Application for a non-material amendment following a grant of planning permission.
Town and Country Planning Act 1990

Unit:		House number: 34	House suffix:	
House name:				
Address 1:	Falcon Gardens			
Address 2:				
Address 3:				
Town:	Littlehampton			
County:				
Postcode (optional):	BN17 7RB			
Description of location or a grid reference. (must be completed if postcode is not known):				
Easting:		Northings:		
Description:

Construction of ramped access at front of property

LU/53/26/HH

JHB.327.534.03

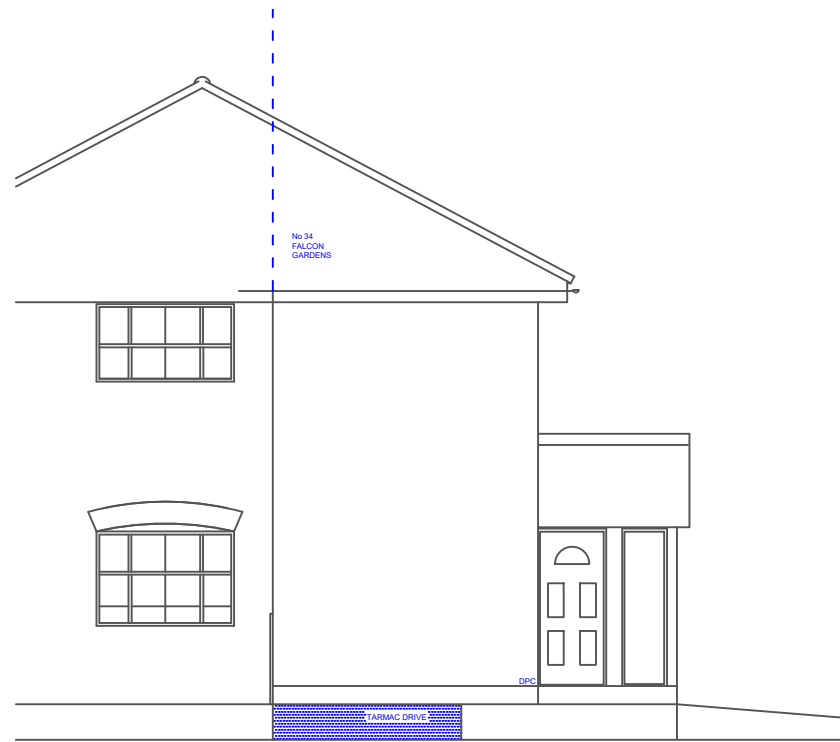
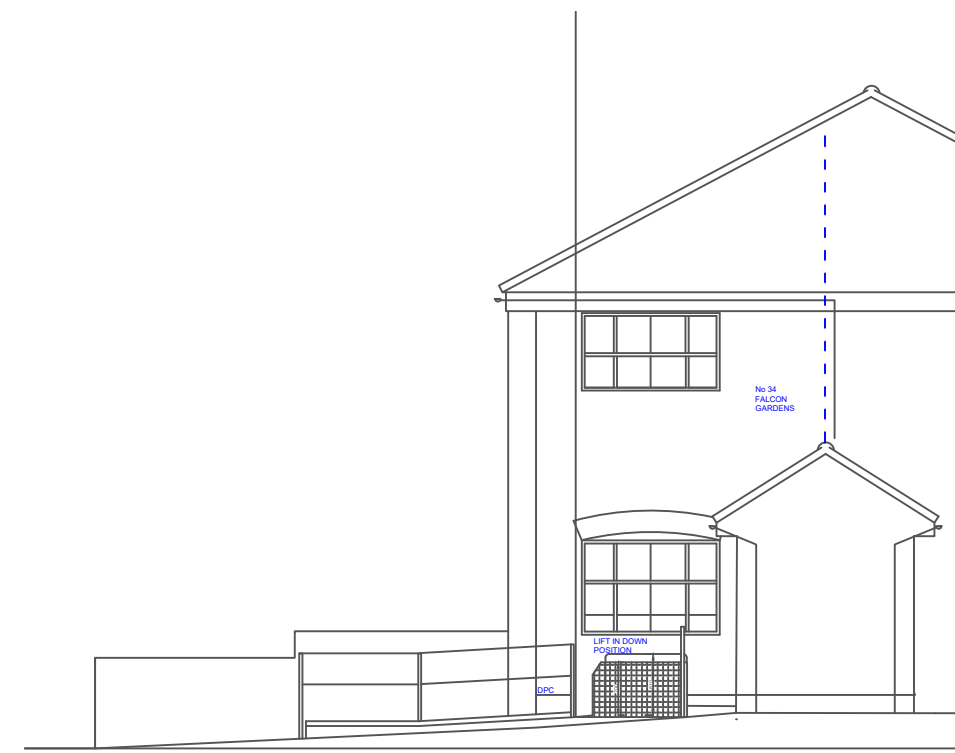
Inclusion of steplift in length of ramp.

Ramp gradient as originally proposed exceeds 1:15. Inclusion of steplift reduces gradient to an allowable incline.
